Stage 1 RSA - Road Safety Audit Addendum Response Report

1.1 This report results from receipt of a Stage 1 RSA Report, undertaken dated September 2017.

drawing number	rev.
A/PHLITTLE-INT.1/TK-1	P6

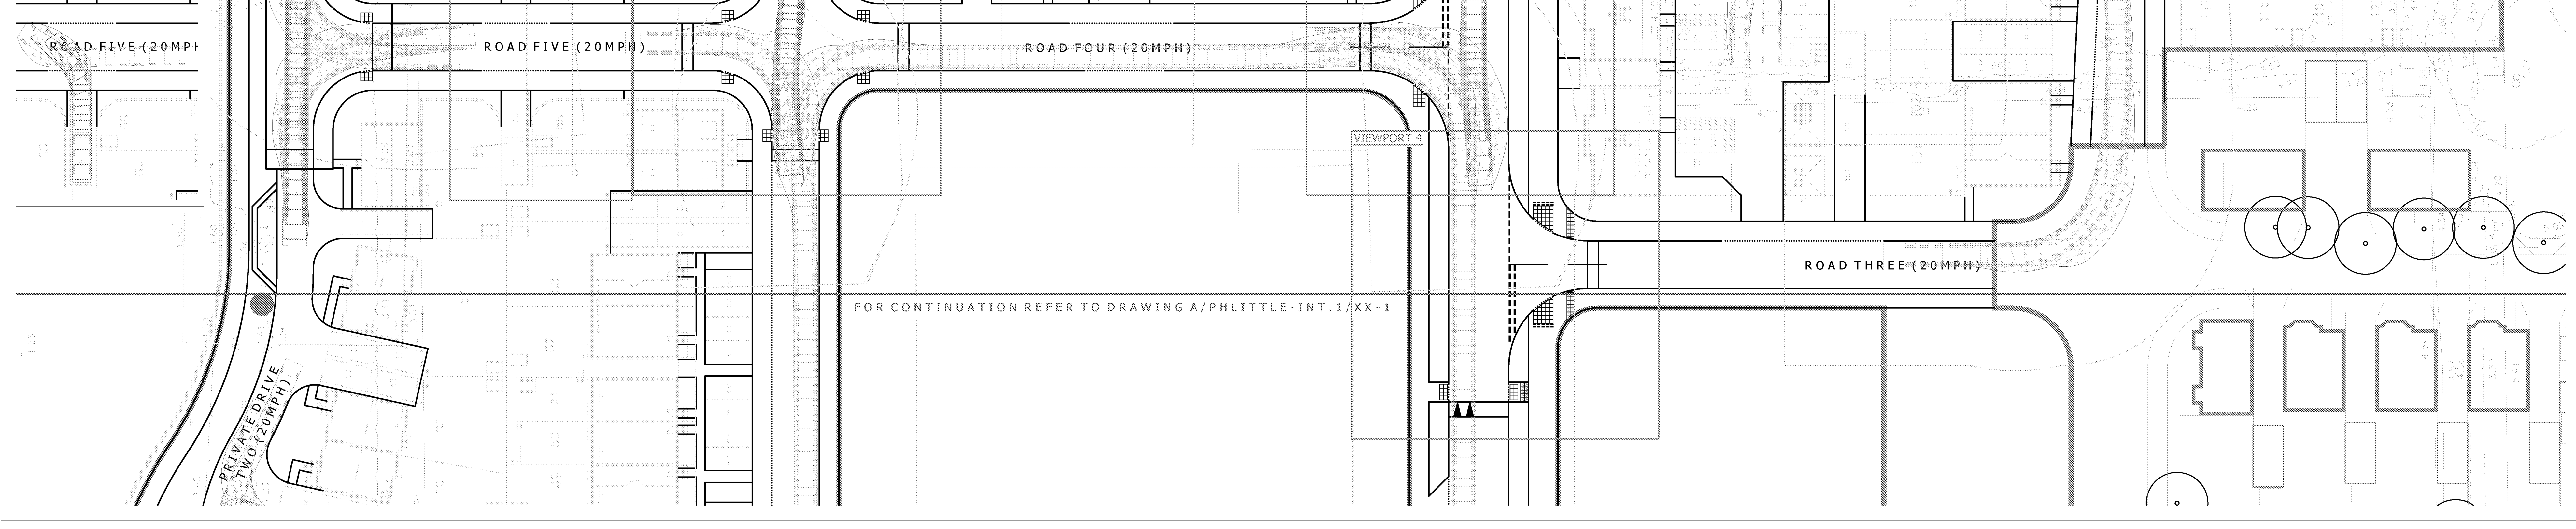
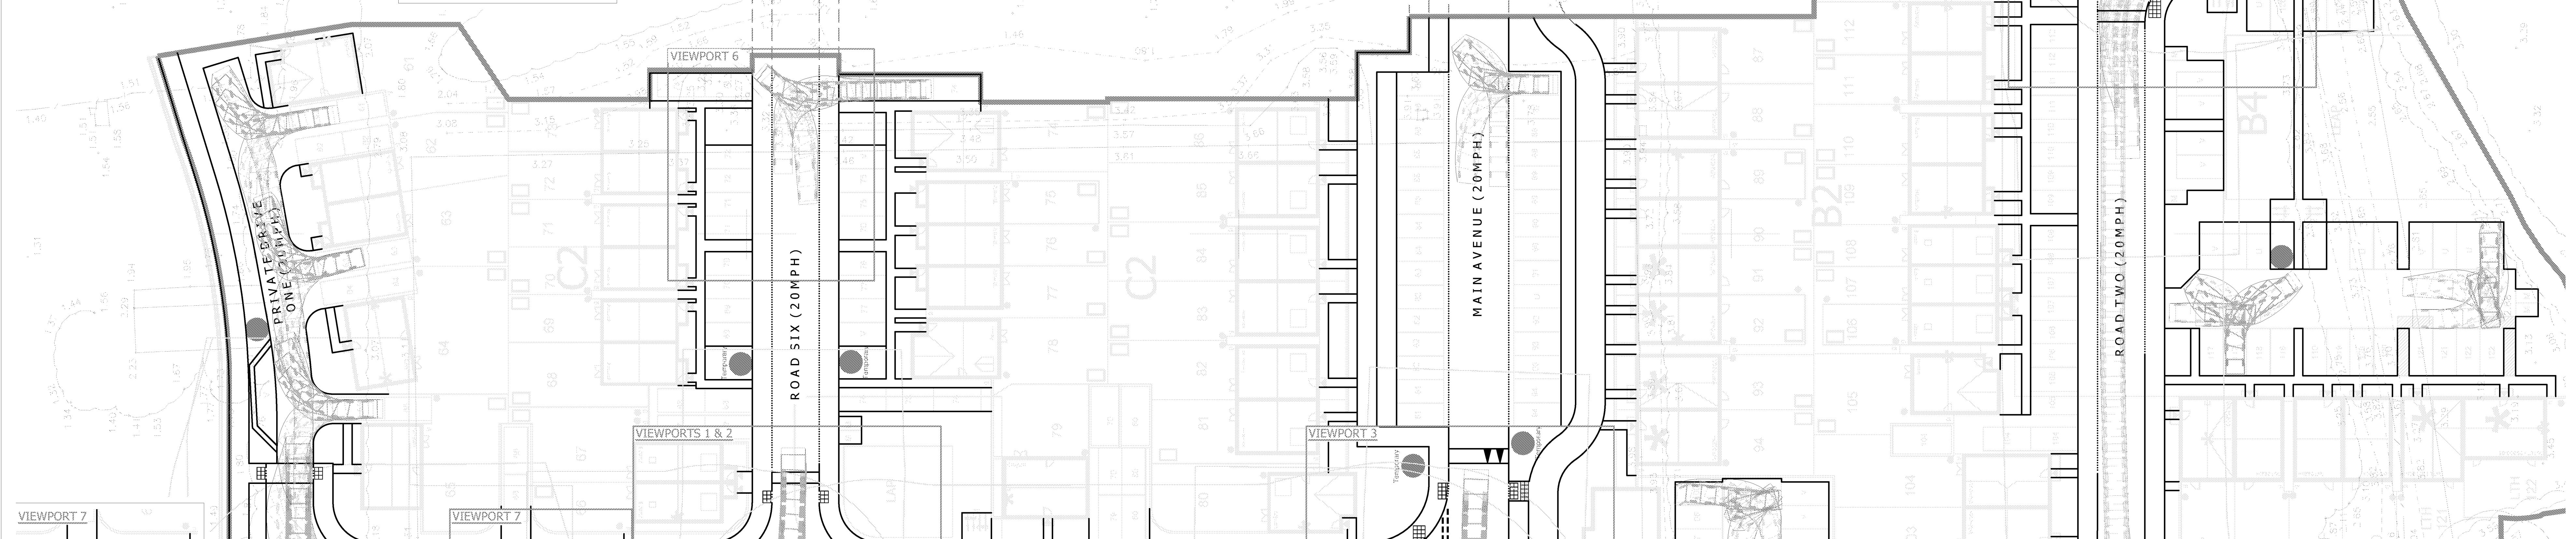
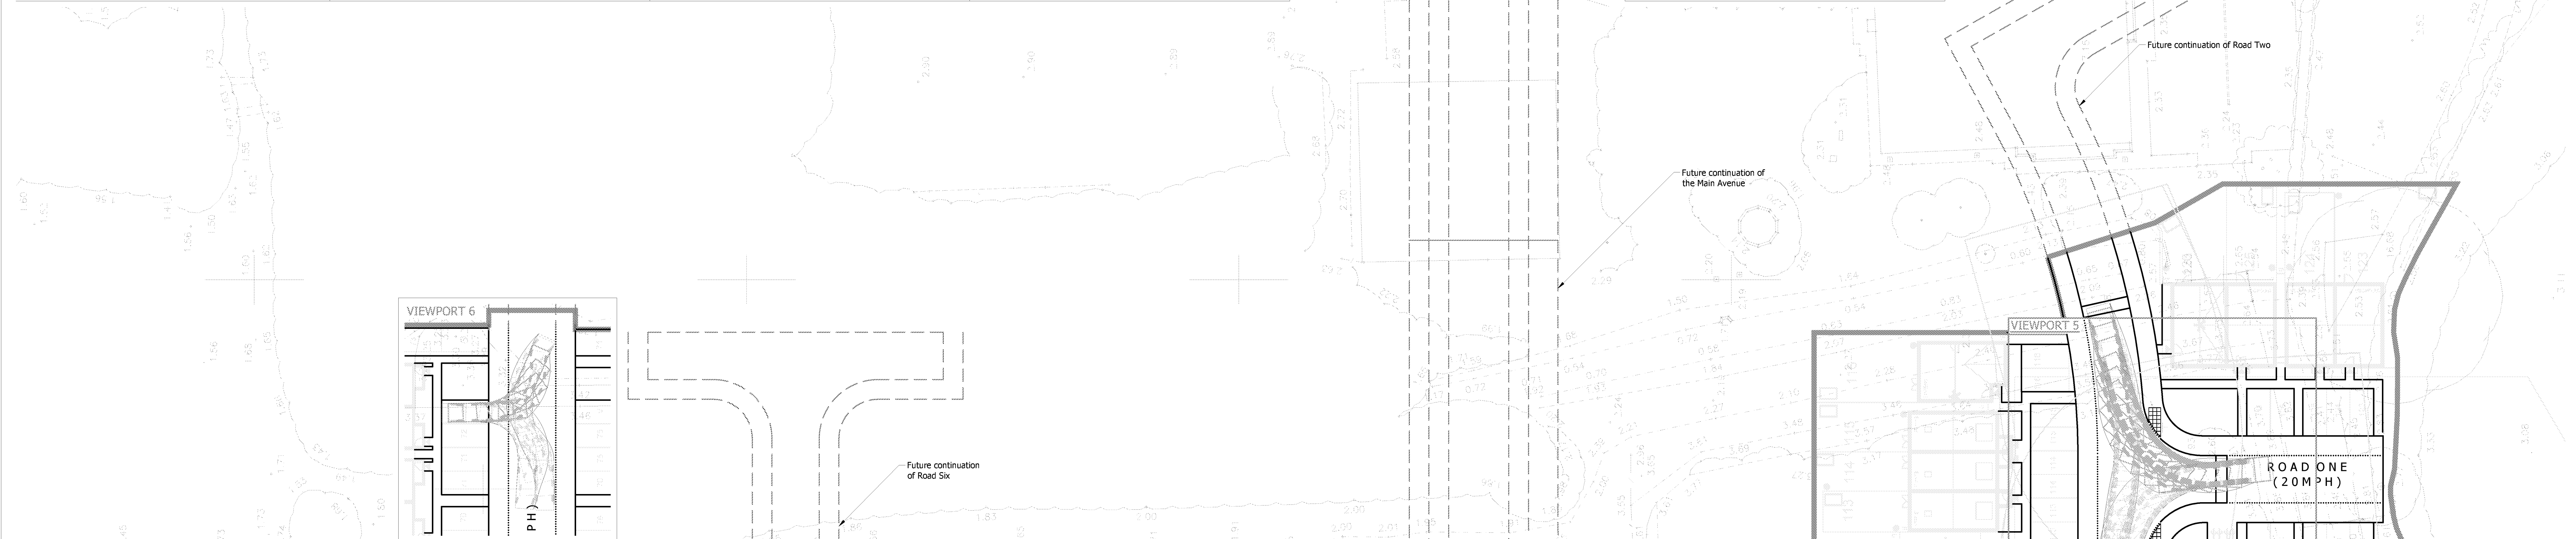
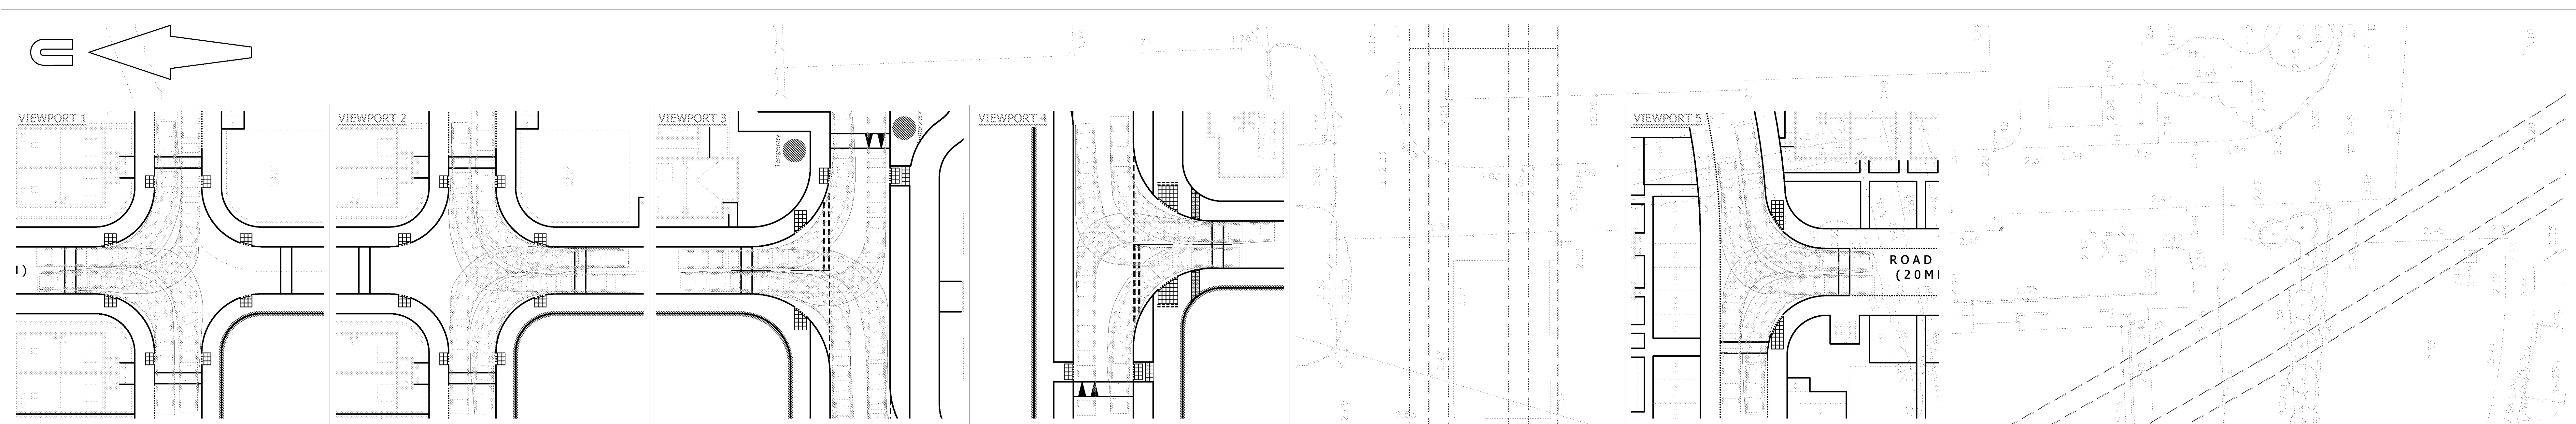
Item	Problem	Recommendation	Designer's Response
3.2	Location: General Summary: Potential obstruction to service vehicle manoeuvres The swept path analysis provided to the Audit Team indicates that a large refuse vehicle is able to service the site without excessive reversing manoeuvres or encroachment on the footway. However, many of these manoeuvres will be obstructed if on-street parking were to occur within the development. This could result in excessive reversing manoeuvres or encroachment on to the footway(s).	If on-street parking does occur within the extent of the swept paths then West Sussex County Council should consider implementing a traffic management order prohibiting vehicles from waiting "at any time" within the extents of the swept paths.	The development shall be provided with designated parking as agreed with the LPA and HA and as outlined in the Transport Statement. The Transport Statement reports (Para 4.14) that there will be ample parking capacity within the site.
